Response to Submissions - Section 75W to Major Project: MP 08_0098 Star City Project Star, Multi-Use Entertainment Facility

On behalf of the proponent, Sydney Harbour Casino Properties Pty Ltd, we have reviewed the submissions received during the public exhibition of the above Section 75W Modification application to Major Project Approval 08_0098 relating to the Star City Multi-use Entertainment Facility (MUEF). We note that whilst comments received from NSW Maritime, Railcorp and Sydney Water do not require a response, a response is required to the comments received from the following public agencies:

1 Proposed Amendments to the submitted Section 75W scheme

4 Section BB
1:250

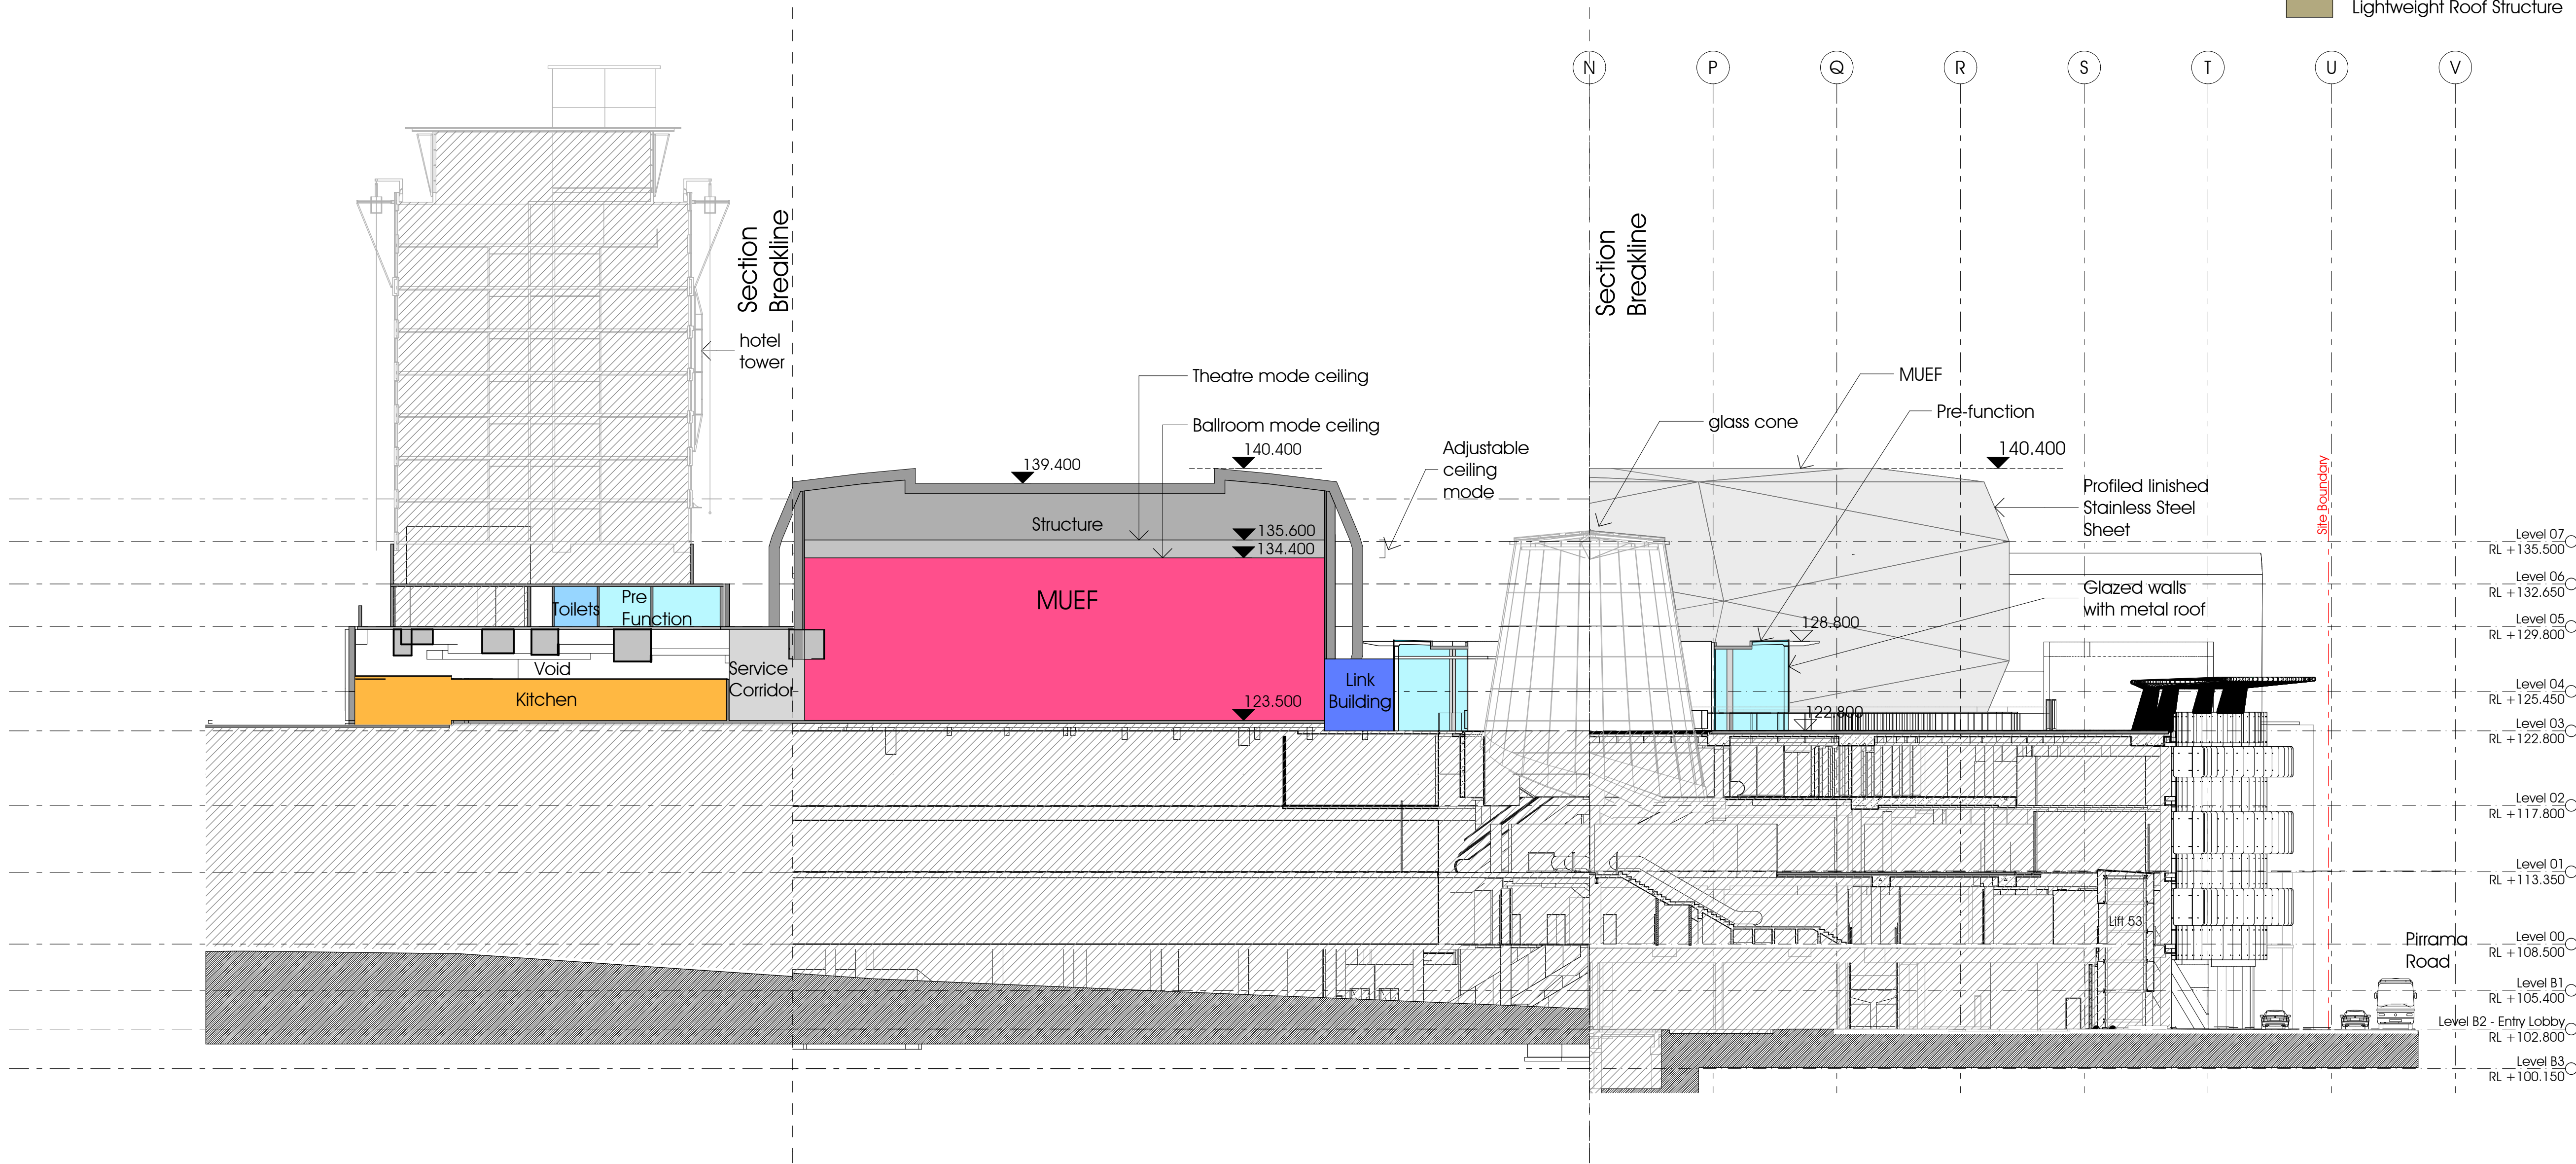
- The methodology adopted in determining proposed height of the MUEF regarding the reliance on a low ceiling.
- The ambiguity of the adopted ceiling level of 5m below the roof; and
- Clarification as to the purpose of an excessive space in between roof and ceiling and therefore whether ceiling height should be actually be higher, such that the calculated height is actually greater than described.

Given the irregular form and variable function modes of the proposed building, it is difficult to define one specific ceiling height. While we note that most buildings have significant roof structure, parapets and roof plant (e.g. lift overruns and chillers) above the height of their topmost ceiling, we have taken the very conservative approach of analysing the visual impact of the topmost structure of the building relative to a height control applicable to the topmost ceiling. Whilst our previous submission identified what we considered to be the ceiling height of the structure, all of our analysis was and is based upon the actual impacts of the topmost points of the structure, which houses all the plant typically provided above roof level.
